Your ref:
Our ref: 22/00987/F
Please ask for: Mrs Joanne Rahman
Direct dial: 01553 616233
E-mail: borough.planning@west-norfolk.gov.uk

Details: **VARIATION OF CONDITION 2 OF PLANNING PERMISSION 20/00198/F: Proposed 4-Bed dwelling and triple garage with associated parking and private amenity space at Mulberry House East End Hilgay DOWNHAM MARKET Norfolk**

I have received a planning application as detailed above but cannot process it until I receive some more information:

Proposed Ground Floor Plan

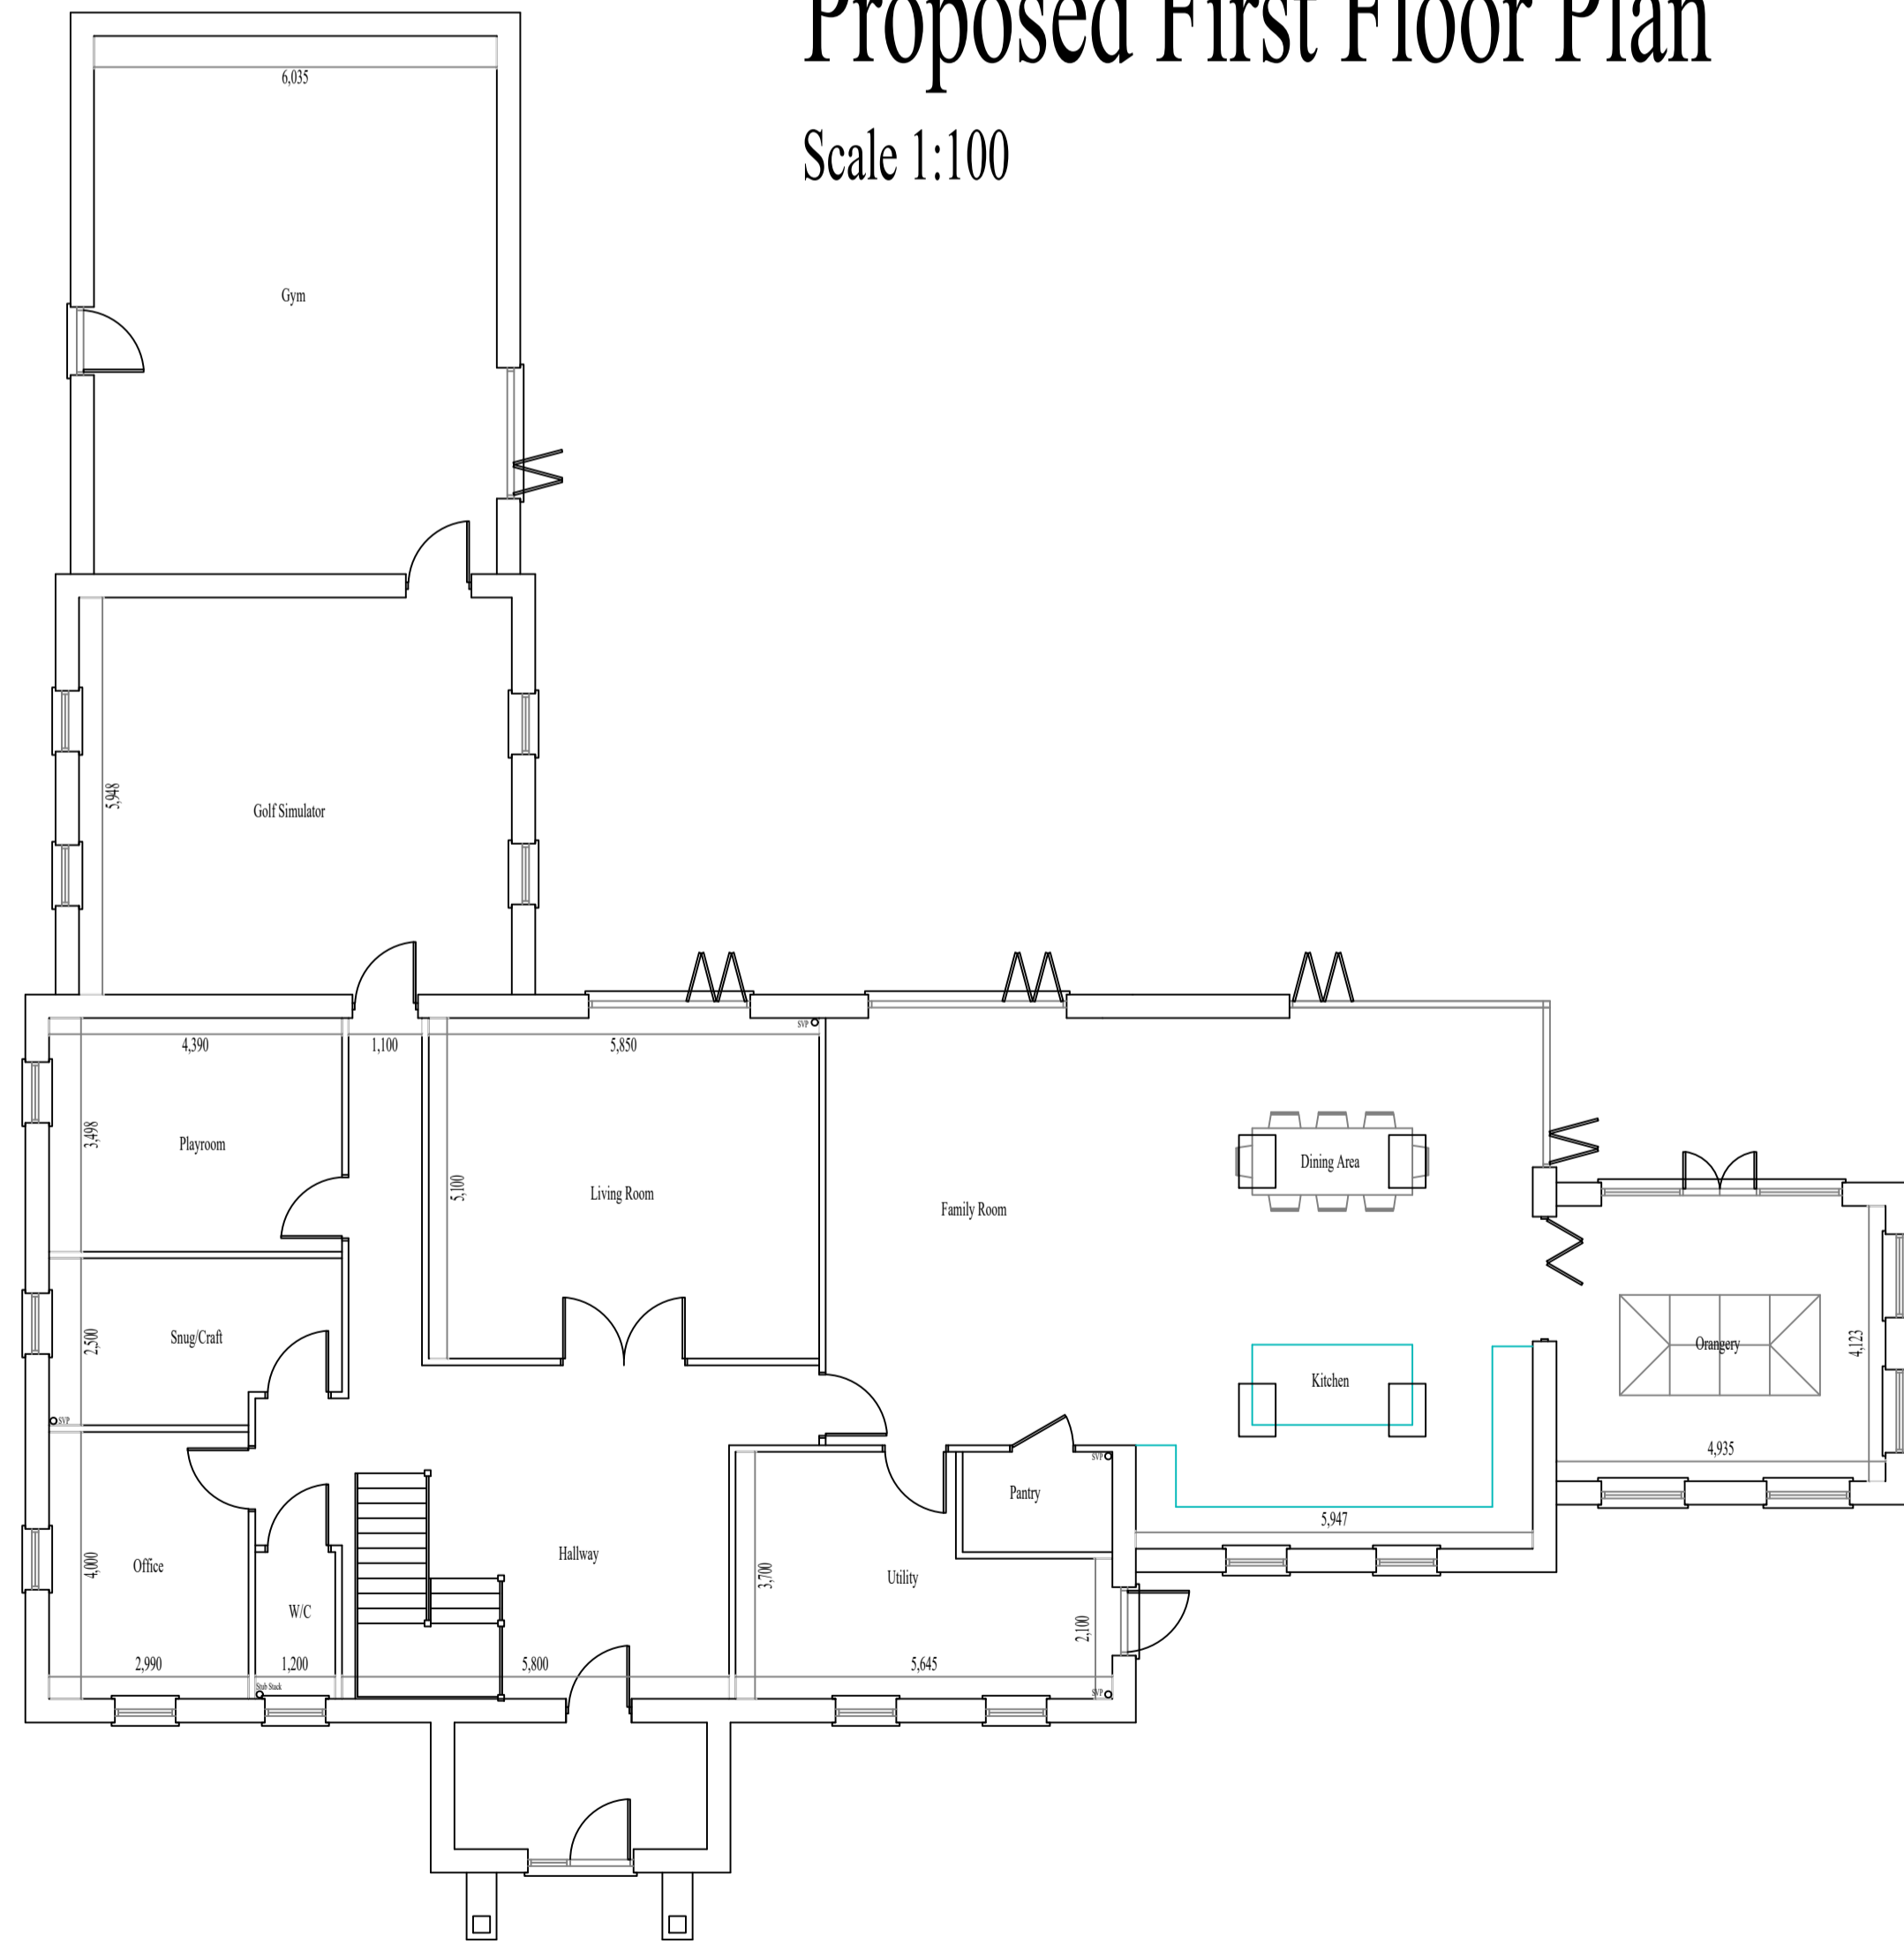
2. There is a window on the proposed east elevation that is not shown on the proposed ground floor plan. Please amend the incorrect plan and resubmit this.
